KIRKLEES METROPOLITAN COUNCIL INVESTMENT & REGENERATION SERVICE

DELEGATED DECISION TO DETERMINE PLANNING APPLICATIONS

Reference No:	2026/62/90976/W
Site Address:	21, New Hey Road, Marsh, Huddersfield, HD3 4AL
Description:	Erection of two storey rear extension and first floor side extension with car port below
Recommending Officer:	Joanna Rednall

DECISION – CONDITIONAL FULL PERMISSION

Drawing
Proposed Elevations

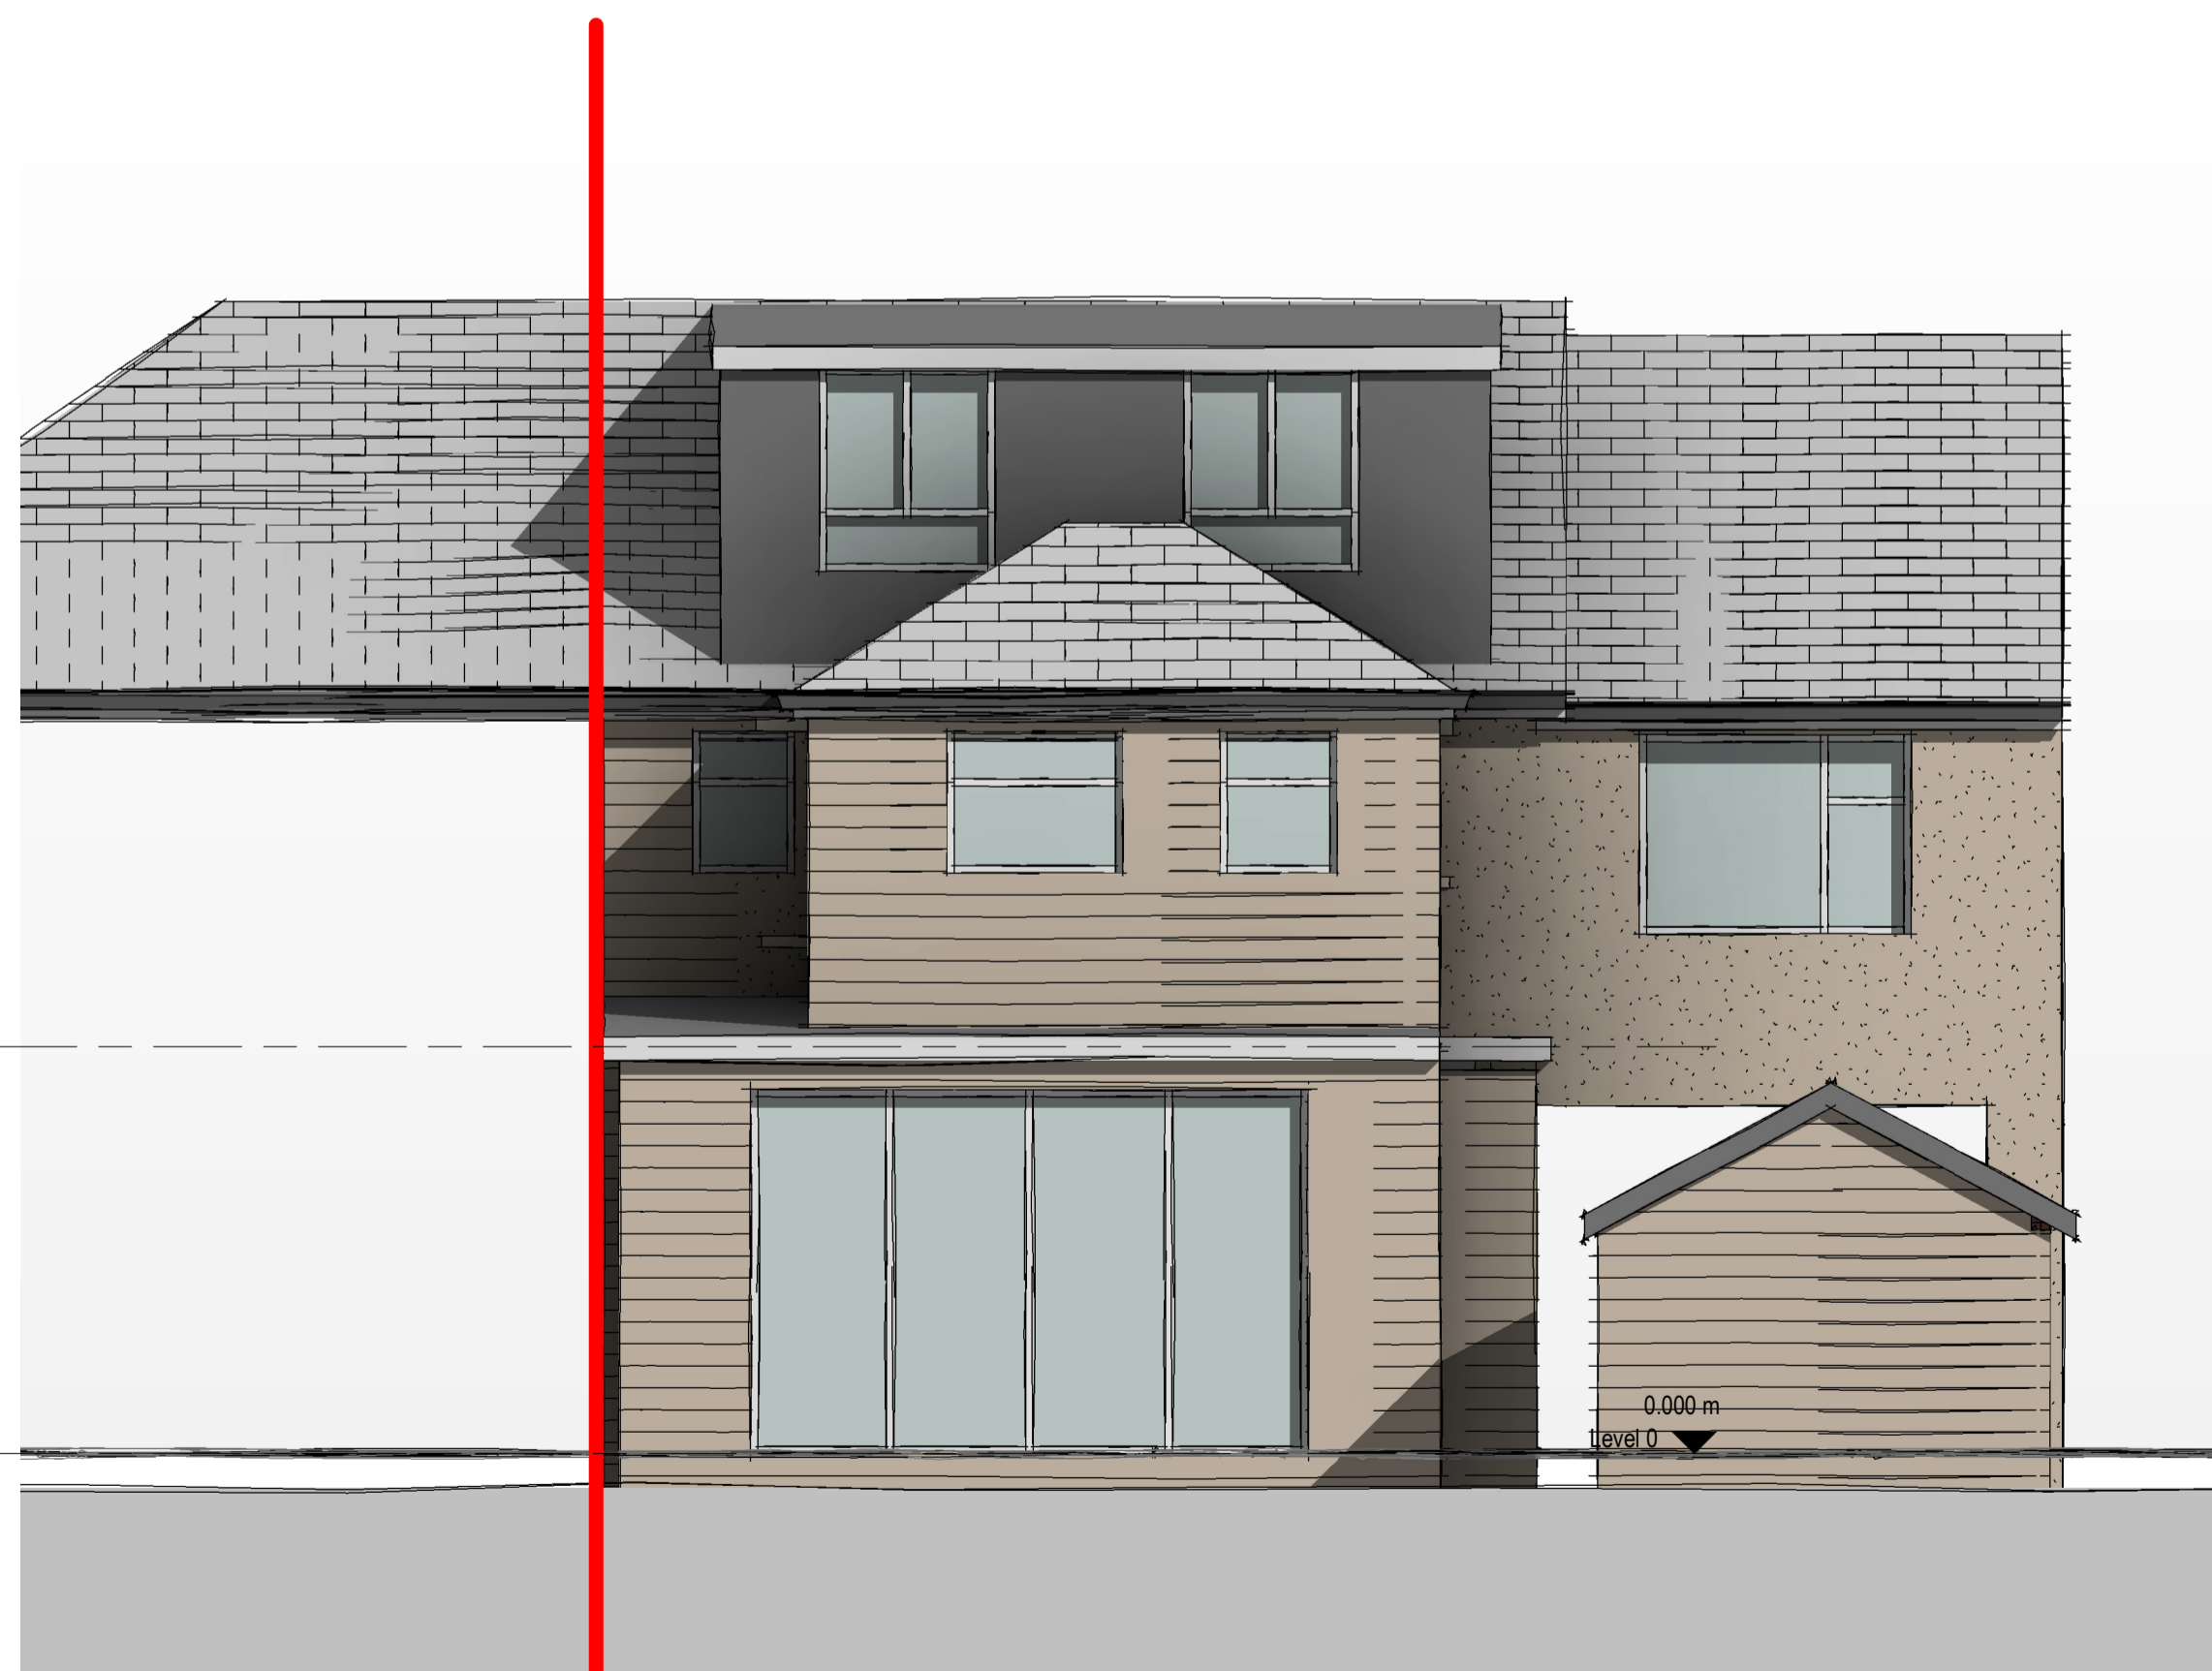
Minor amendments were made to the material proposed to elevations to ensure that the proposal would adequately harmonise with the host. The amended plans also demonstrated a revised roof design to the side extension and also reduced the size of the first floor element of the two storey extension to rear. Amended plans were received on 5 June, and the application has been progressed to determination on the basis of these.

The proposed materials comprise natural stone at ground-floor level with a cream-coloured render to the first floor. These materials reflect those used on the host dwelling and would ensure the extension integrates well with the existing building. The ground-floor roof would take the form of a lean-to, while the first-floor roof would be flat. Although a flat roof is not a preferred design approach, the presence of the existing rear dormer on the host property limits the feasibility of achieving a roof which ties into the rear roof slope. The first floor element of the proposal is of a limited scale and not in a prominent part of the site, largely screened by the main public vantage points by the host property. In this context, the flat-roofed design is considered a practical and visually acceptable solution in this case. Weight is also afforded the fact that the proposal would see a hipped roof design to the first floor side, this will see a pair of semi detached properties which currently have a gable and hipped roof, harmonise in terms of both having hipped roof designs.

The proposed side extension would appear visually subordinate to the original dwelling, with its overall massing noticeably smaller than that of the host property. A set-back of approximately 300 mm from the front elevation would provide a clear visual break, helping to distinguish the extension from the main form of the house. The hipped roof design, together with a lowered ridgeline, reflects the character of the semi-detached pair and ensures the extension reads as a secondary element rather than competing with the host in scale or prominence.

3. The external materials used in the construction of the walls of the development shall be stone and render as indicated upon submitted drawing titled 'Proposed Elevations' ref: UD-496 received 5th June 2026. The render shall be of a cream colour finish to match the host property. The roofing materials of the first floor side extension hereby approved shall in all respects match those used in the construction of the existing building. The development shall not be brought into use until it has been completed with the materials of construction approved by this condition which shall be retained thereafter.
